Architectural Design Report - Response to Submission

# UNSW Health Translation Hub

This report has been prepared on behalf of UNSW as an addendum to SSD 10822510 for the Health Translation Hub building.

The report has been compiled to respond to the design-related submissions received by the Department of Planning and Environment and Randwick City Council during the public exhibition of the UNSW HTH.

1
DA1001
UNSW Campus Connection_Ground Floor Plan
SCALE: 1 : 100

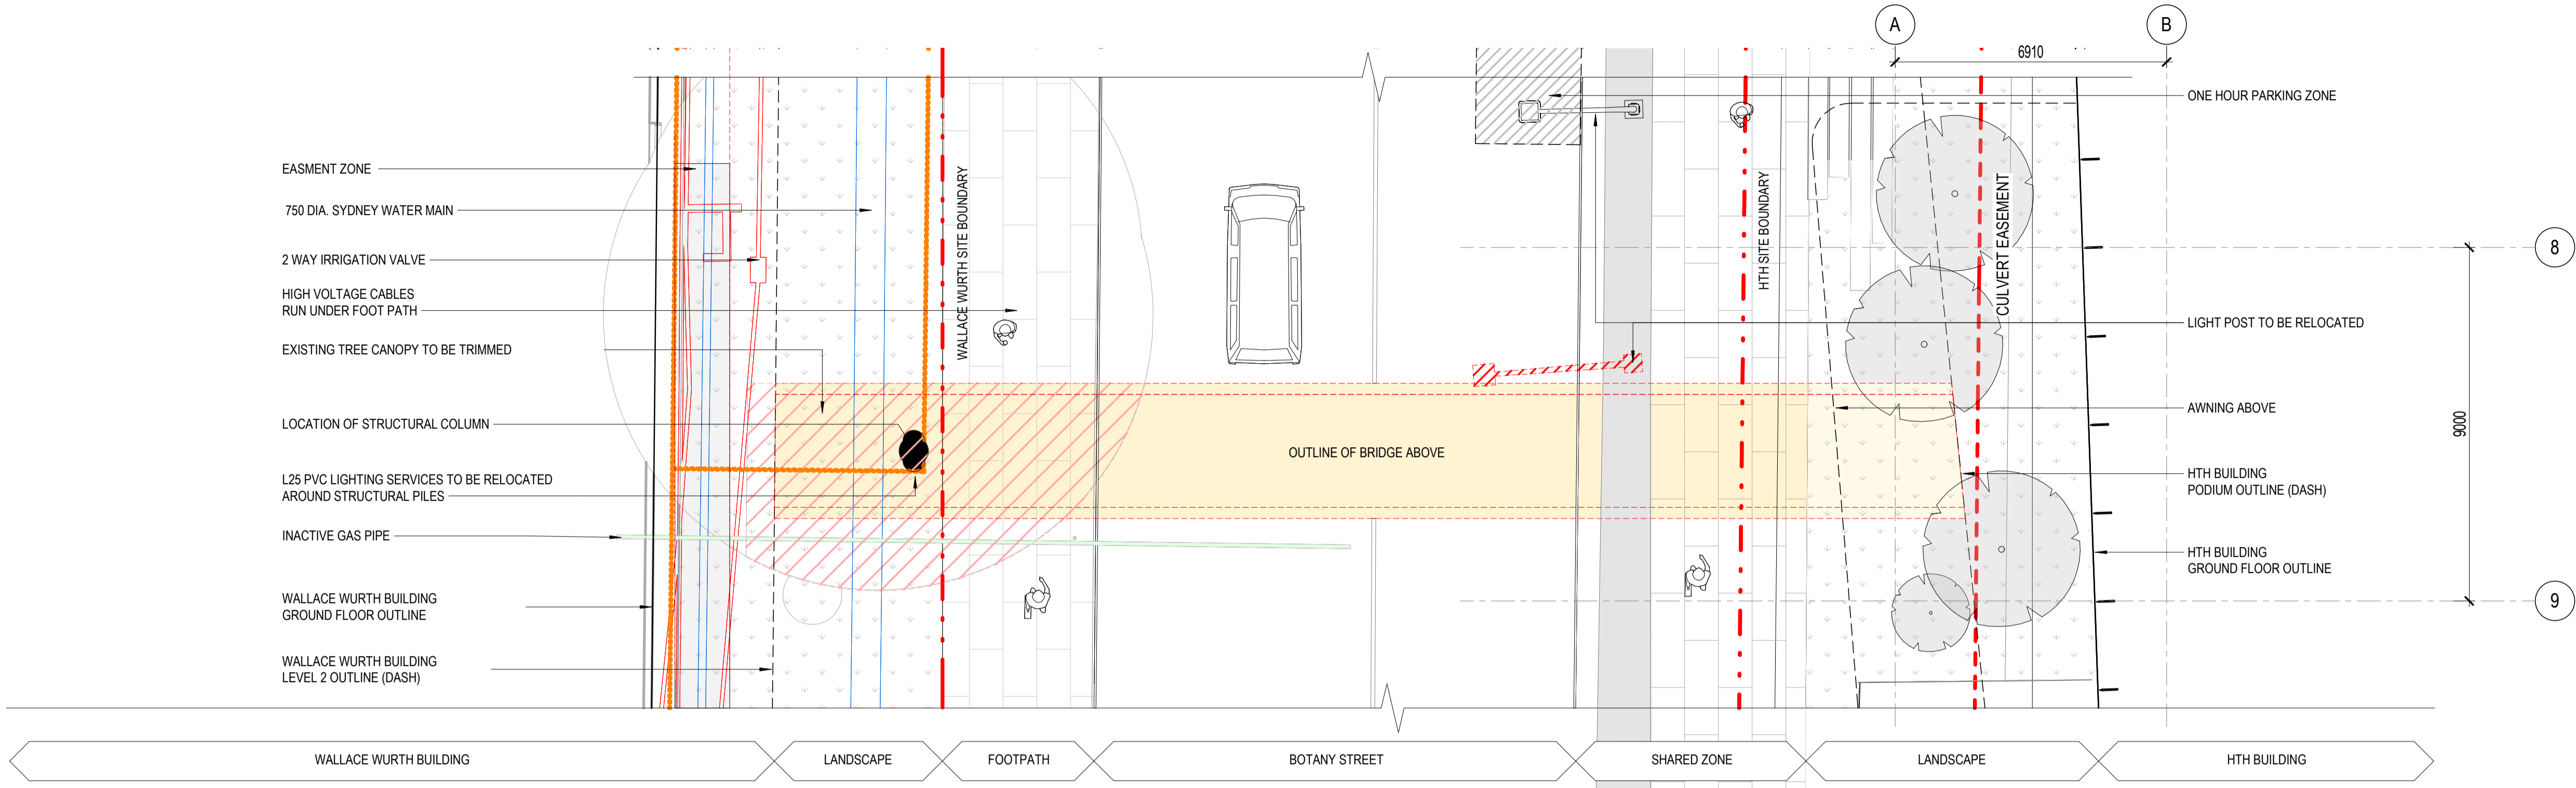
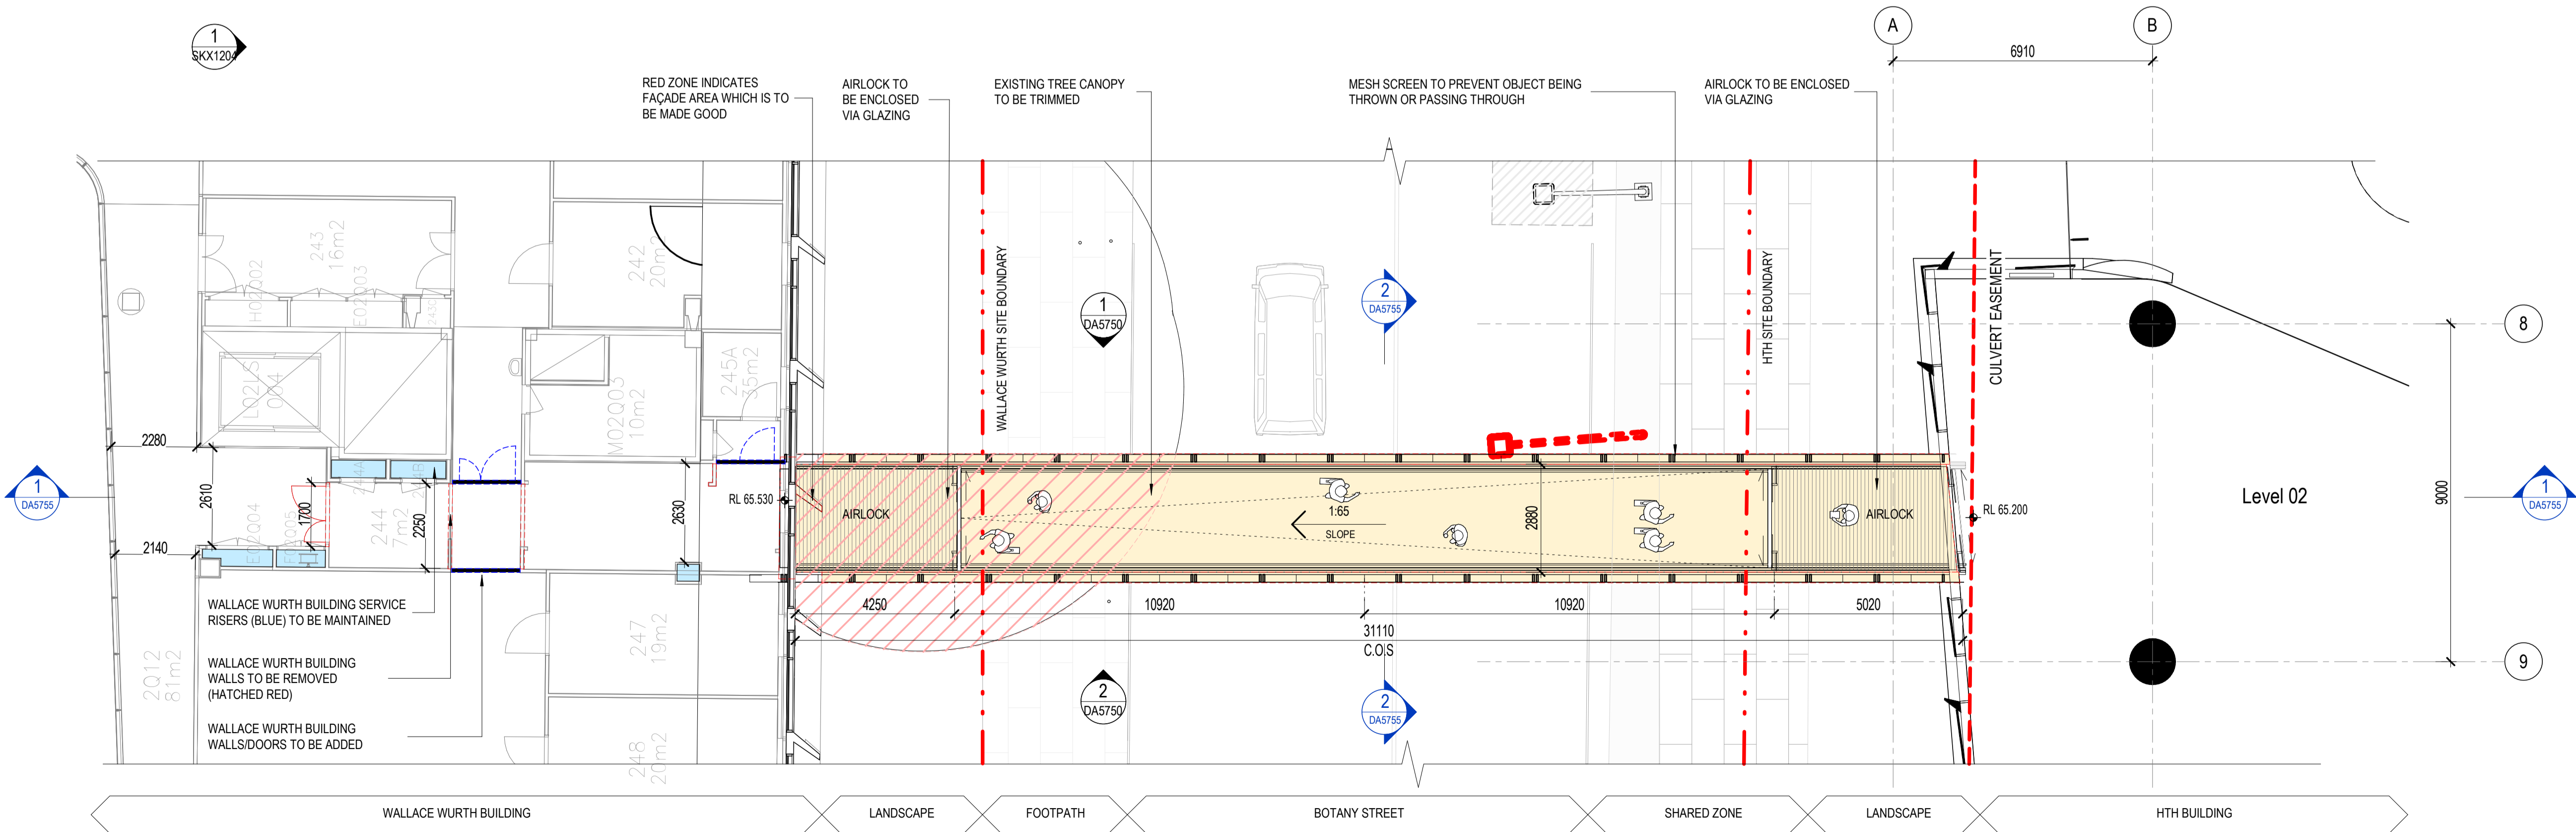
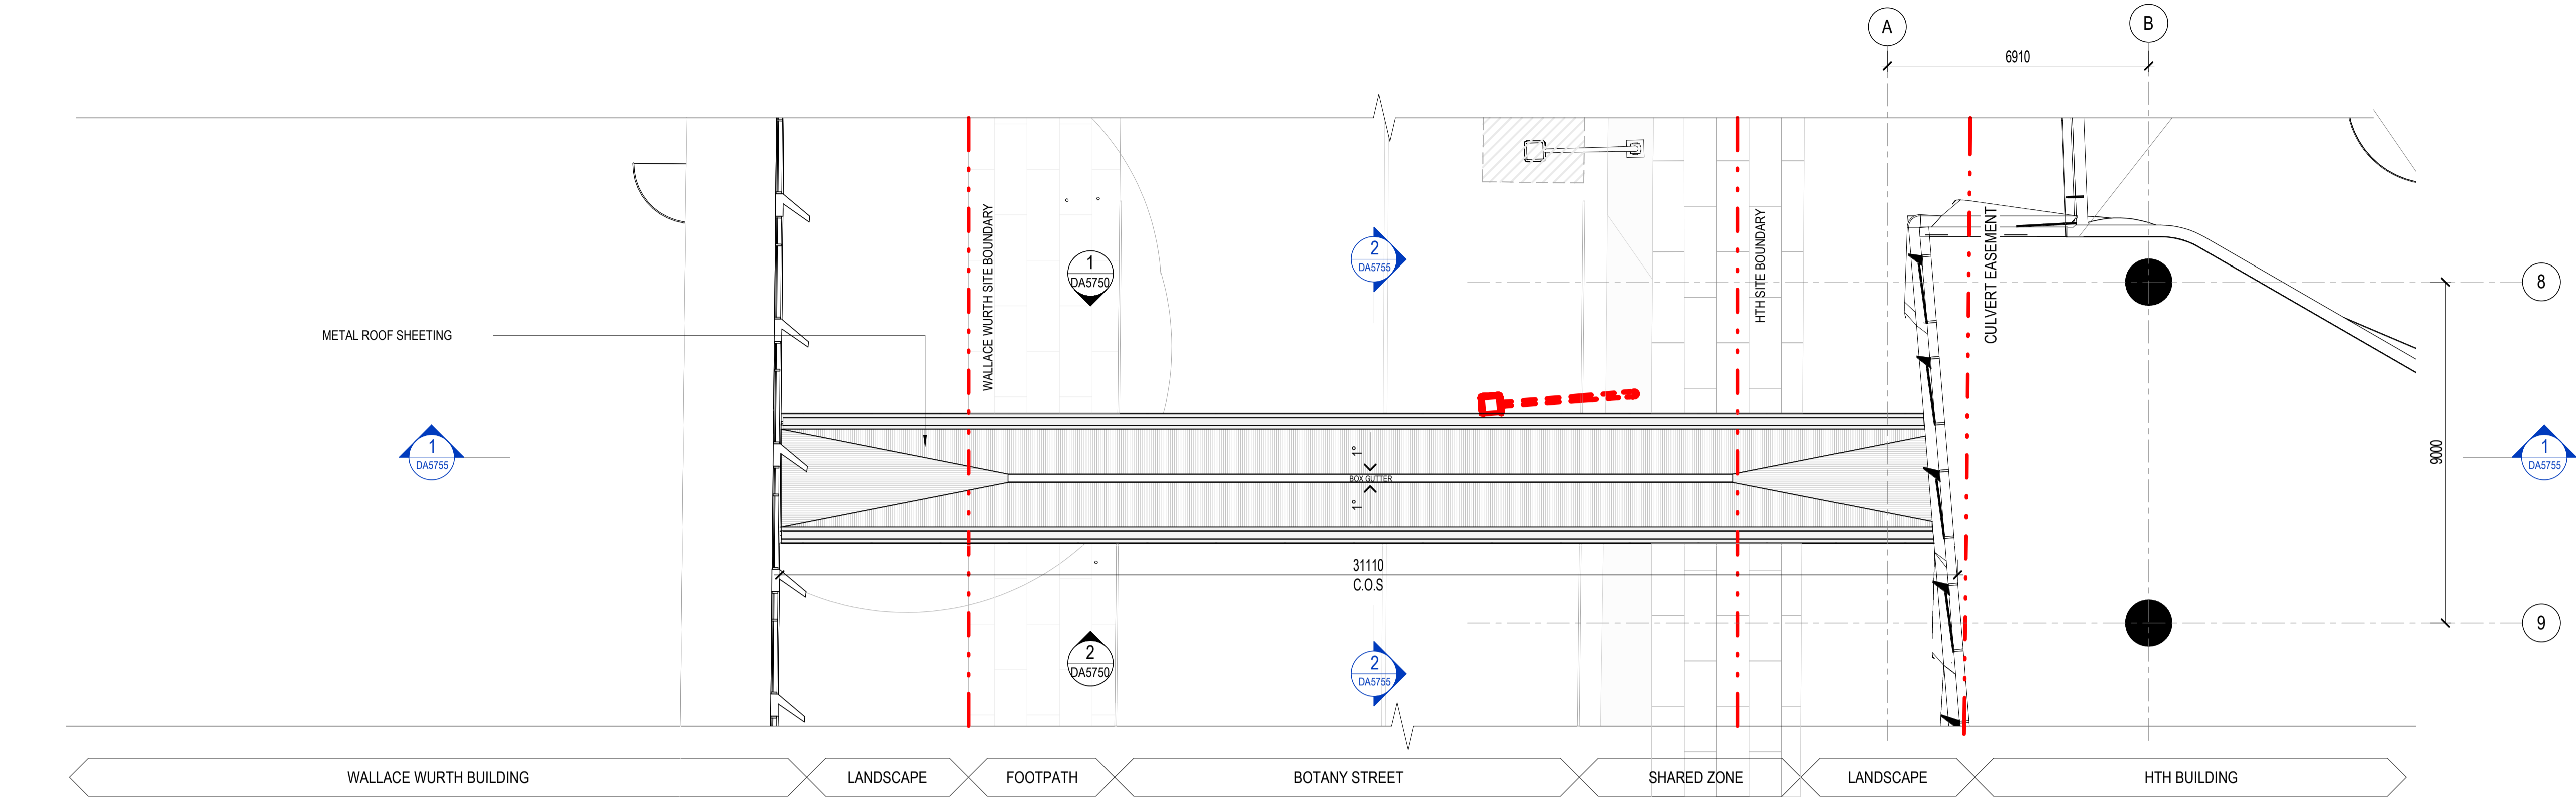
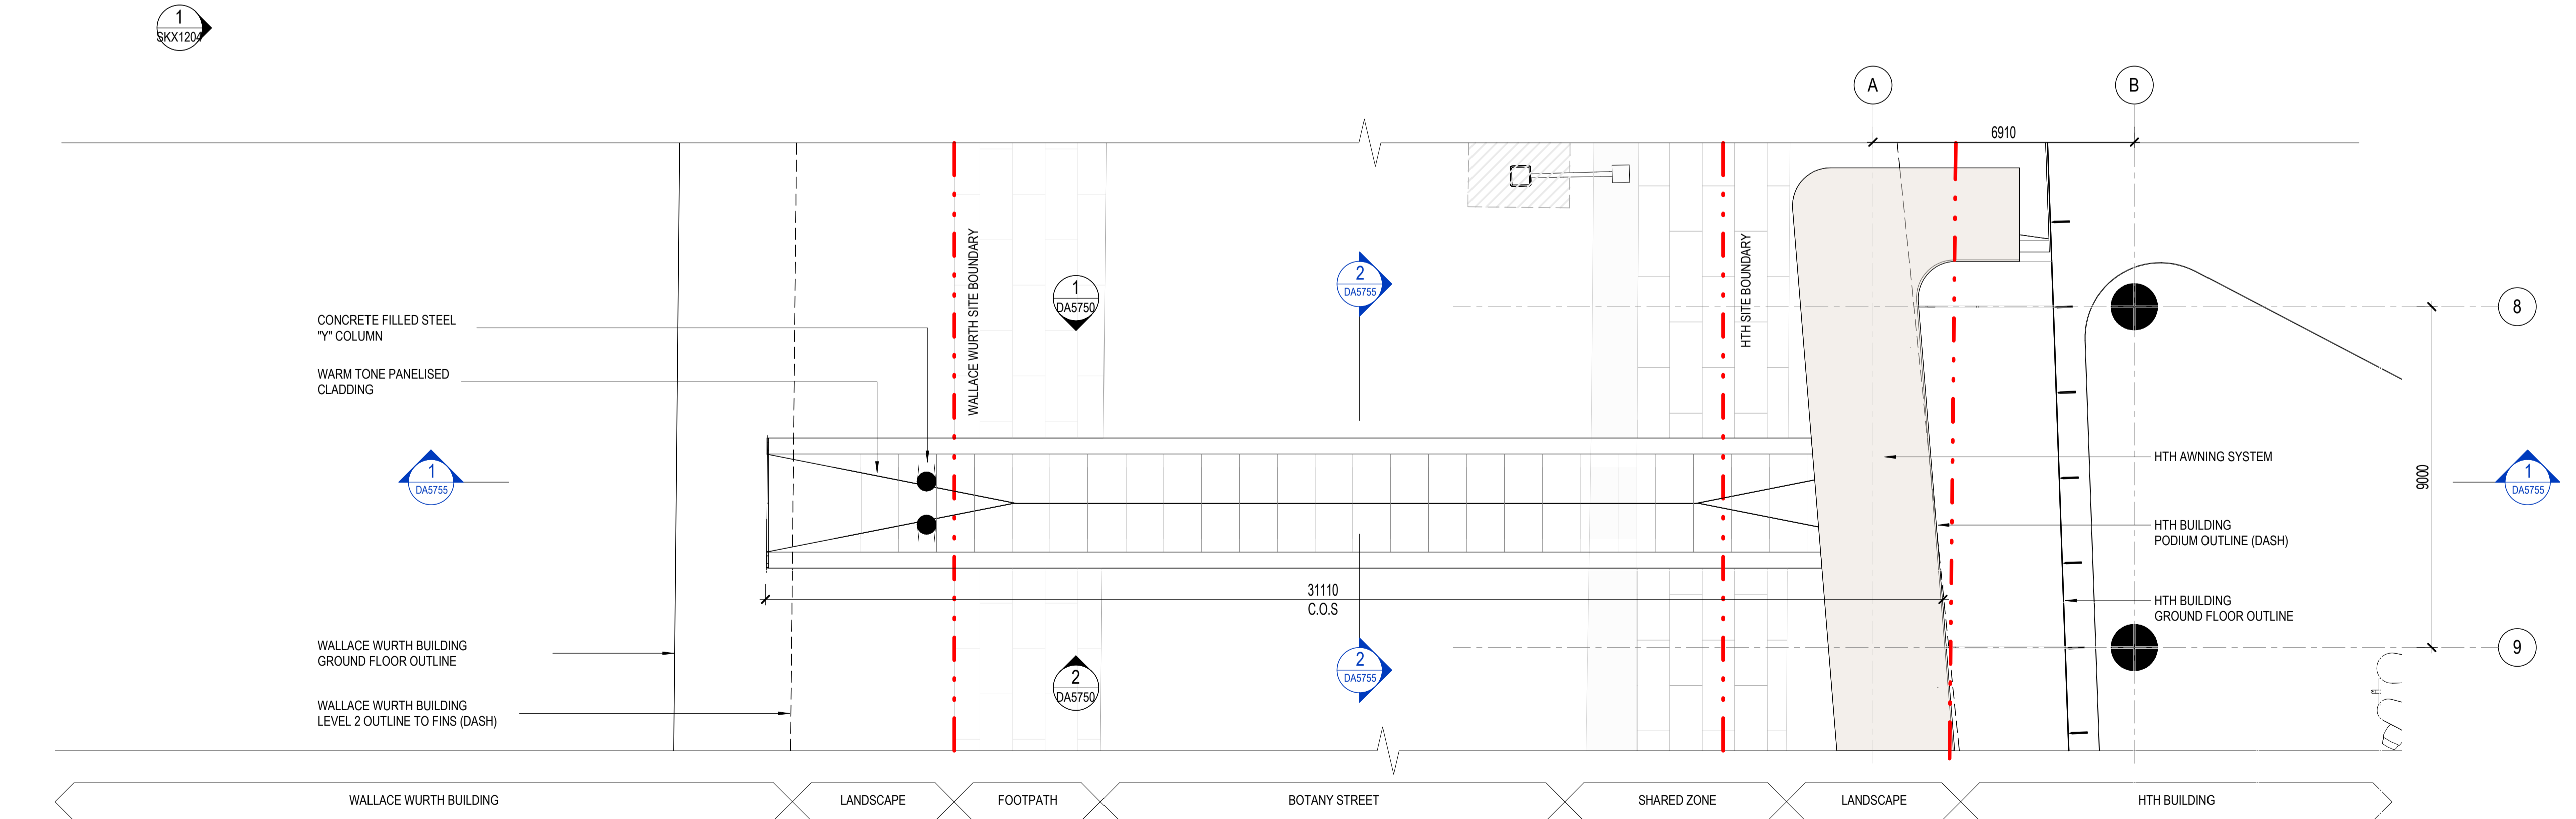
*Council questions the reason for providing a central open-air section with glazed airlocks at each end of the bridge. A continuous glassy enclosure may provide better weather protection for people crossing the bridge and remove the need for two airlocks.*

The UNSW campus bridge connection has been designed as a passively ventilated space with a fine mesh throw screen along its elevations to remove the need for mechanical services. This improves the internal ceiling heights by reducing the ceiling/roof depth to create a lightweight aesthetic, while also maintaining the appropriate weather protection.

The glazed airlocks at each end of the bridge provide buffers between the bridge and adjacent conditioned spaces for both buildings, allowing internal conditions and comfort to be maintained in these areas. Being glazed, the air locks should not be visible and impact the overall aesthetic of the bridge.

During the next stages of the project, detailed stakeholder engagement will be undertaken and should there be a requirement for the bridge to be full enclosed, there is an opportunity for the bridge to be completely glazed and conditioned .
